Application No: AW/1/25/HH

Site Address: 27 Aldwick Avenue Aldwick PO21 3AQ

Description of works: Part single, part two storey side and rear extensions, conversion of garage to habitable use, hip to mansard roof extension with dormers, and alterations to fenestrations.

Thank you for your internet representation made on 4th February 2025 which has been recorded as an objection with the comments as follows:

Proposed parking

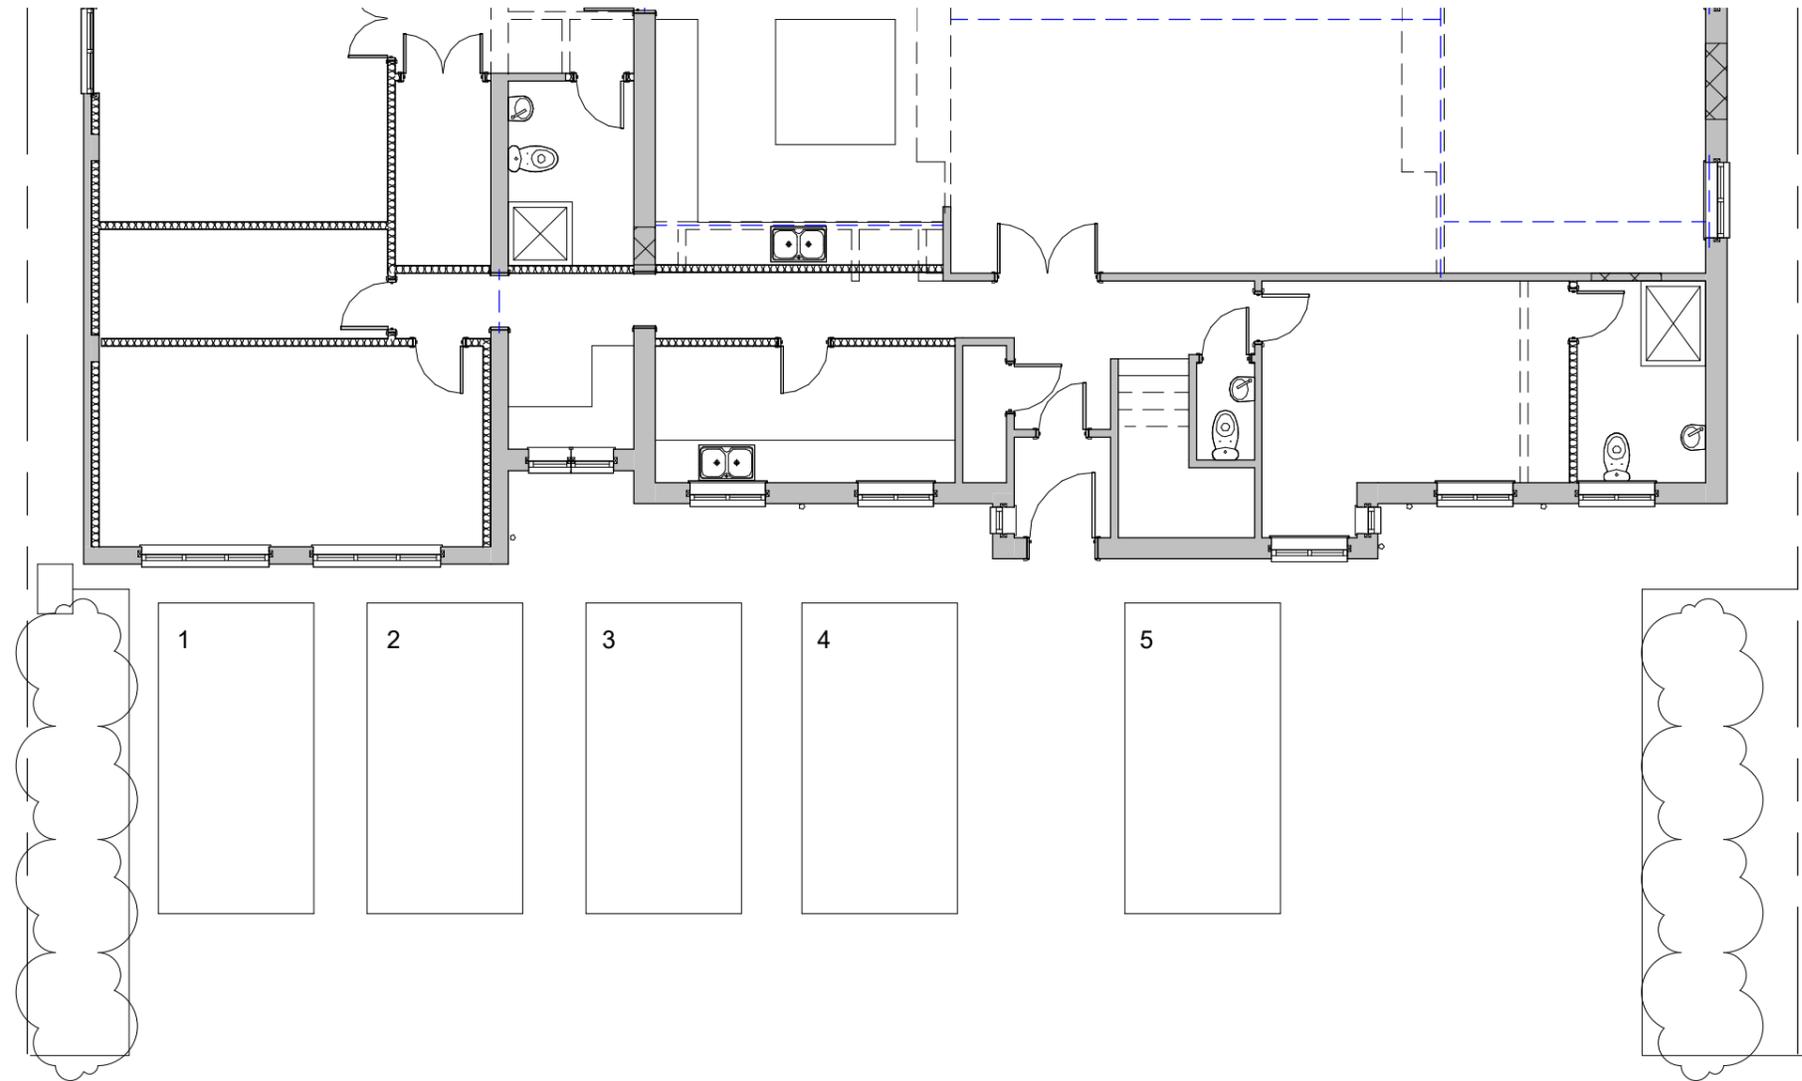
Bearing in mind that the double garage has been changed to a Study, Plant room, Wine Store and Cinema, the plans do not indicate off road parking availability.
